DELEGATED DECISION TO DETERMINE PLANNING APPLICATIONS

Reference No:	2024/62/92590/W
Site Address:	36, Syringa Street, Marsh, Huddersfield, HD1 4PD
Description:	Erection of extension to rear, refurbishment of basement with steps to front, formation of driveway and drop kerb
Recommending Officer:	Molly Storer

DECISION – Conditional Full Permission

Proposed Ground Floor Plan Scale 1:100

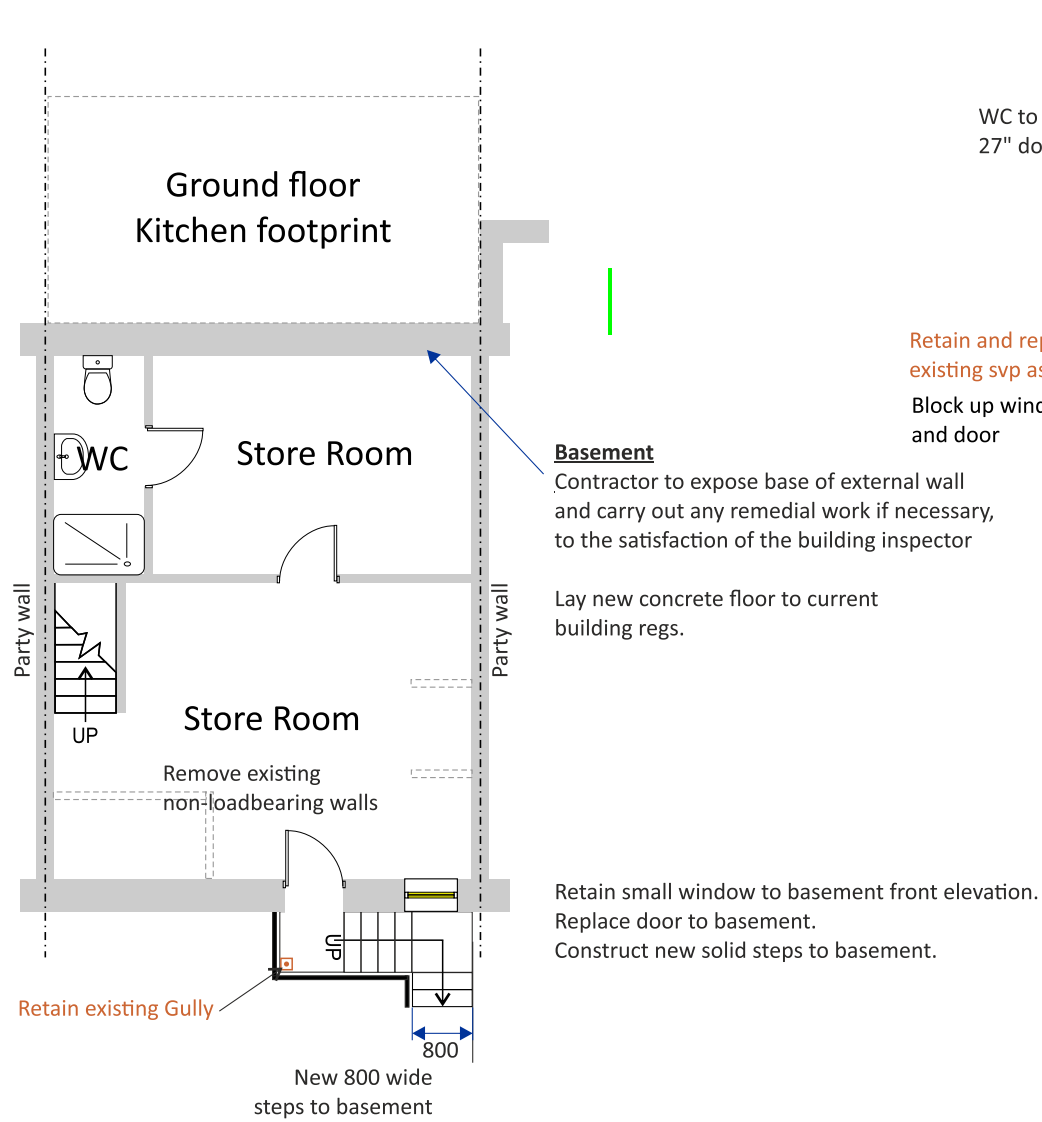
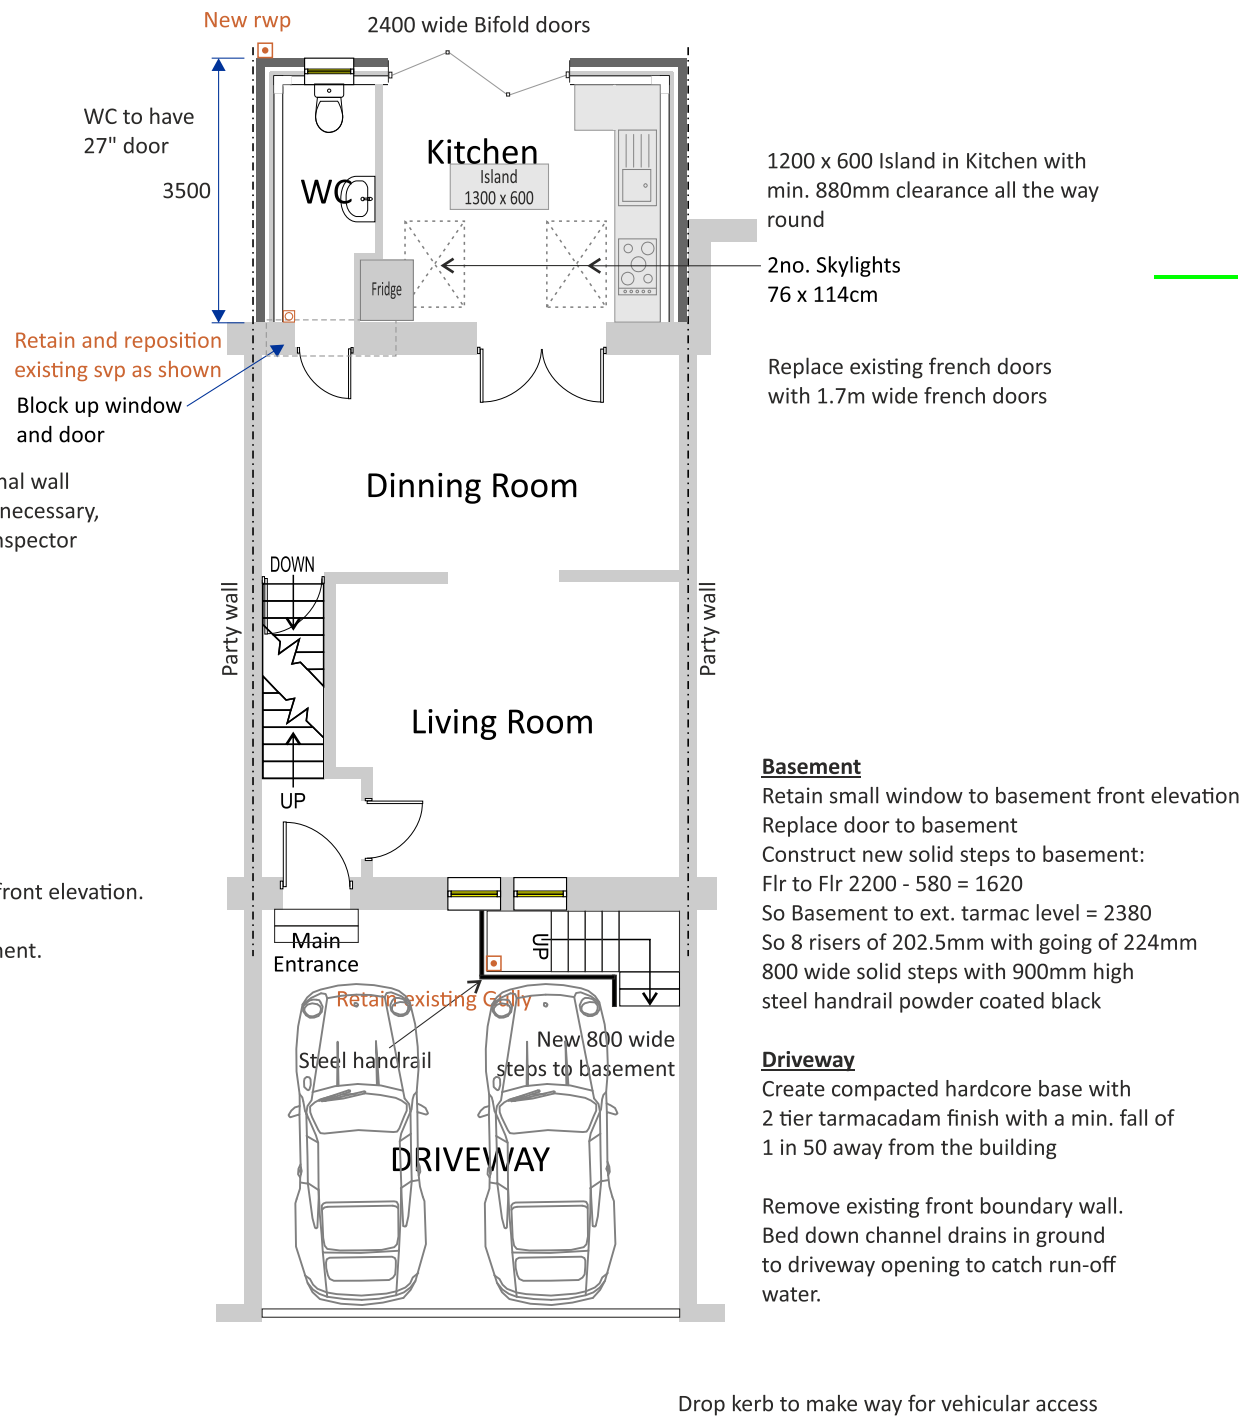
The agent was contacted due to a formal objection from highways. The objection was due to there not being enough space at the site for two off street parking spaces. The agent sent amended plans which showed external stairs removed from plans which left space for a car parking space. This was deemed acceptable by highways officers.

KC Highways: Objected to the original application which proposed two parking spaces as well as external steps to the basement to the front of the property.

These parking spaces scale 4.6m in width x 4.4m in length. These dimensions do not meet the recommended minimum dimensions of 4.8m x 5.0m and in any case the proposals leave insufficient space for pedestrian access to the dwelling. The proposal will result in vehicles over hanging the footway along Syringa Street which would not be in the best interests of highway safety. On-street parking along this section of Syringa Street will result in poor sight lines from the proposed parking spaces onto Syringa Street. Intervisibility between pedestrians and vehicles exiting the proposed parking spaces could be poor because of the height of the adjacent boundaries. HDM would recommend that the proposed parking is removed, or this application should be refused on highway safety grounds.

The agent submitted amended plans showing the external steps removed and only one parking space. This was supported by highways officers.

The space provided is considered acceptable to facilitate 1 no. off street parking spaces which is considered acceptable in this case and in accordance with the Highways Design Guide SPD, Key Design Principle 15 of the House Extensions and Alterations SPD and Policy LP22 of the Kirklees Local Plan.

Proposed Basement Floor Plan Scale 1:100

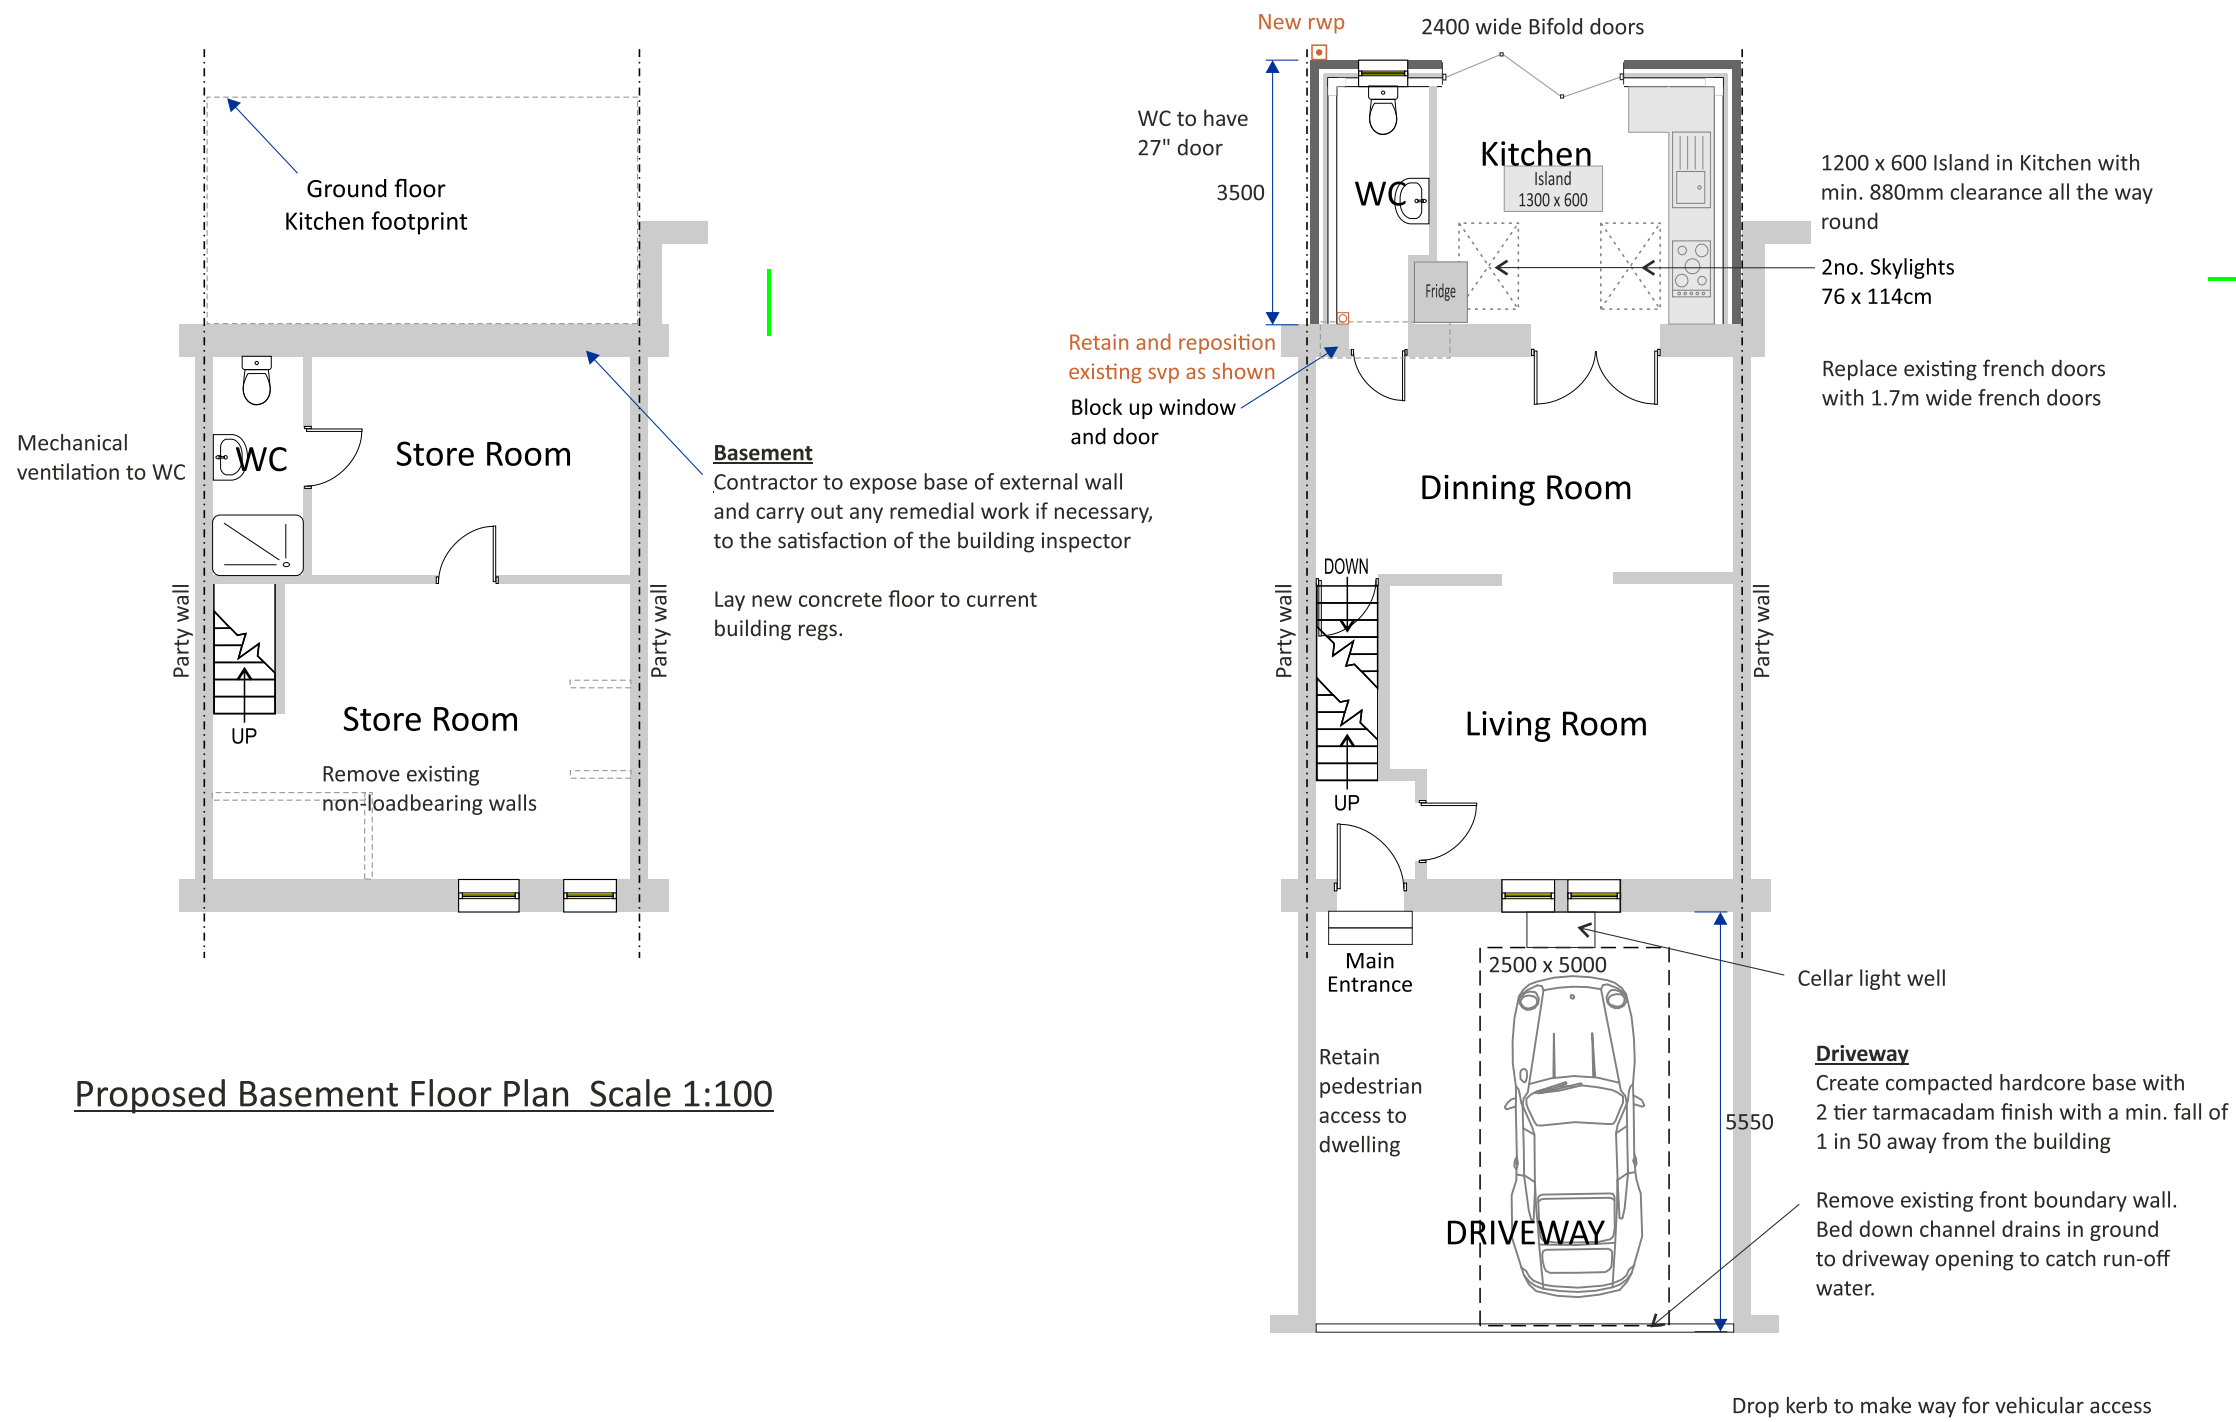
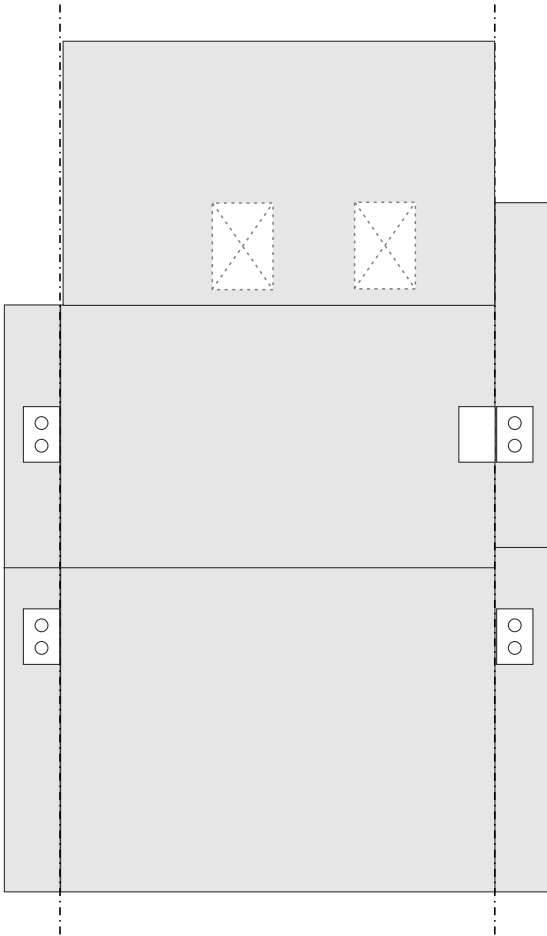
- Excavation will impact foundations and weaken joining walls.
- May increase damp/flooding.
- Concerns that it will have an impact on the structural integrity of the adjacent properties.
- Issues such as water damage and mould may arise.
- Concerns with regard to electrical or water works.

There are no visual or residential amenity concerns with regard to the refurbishment of the cellar. The external steps have now been removed from the scheme. These concerns are not material planning considerations and will be assessed at the building control stage.
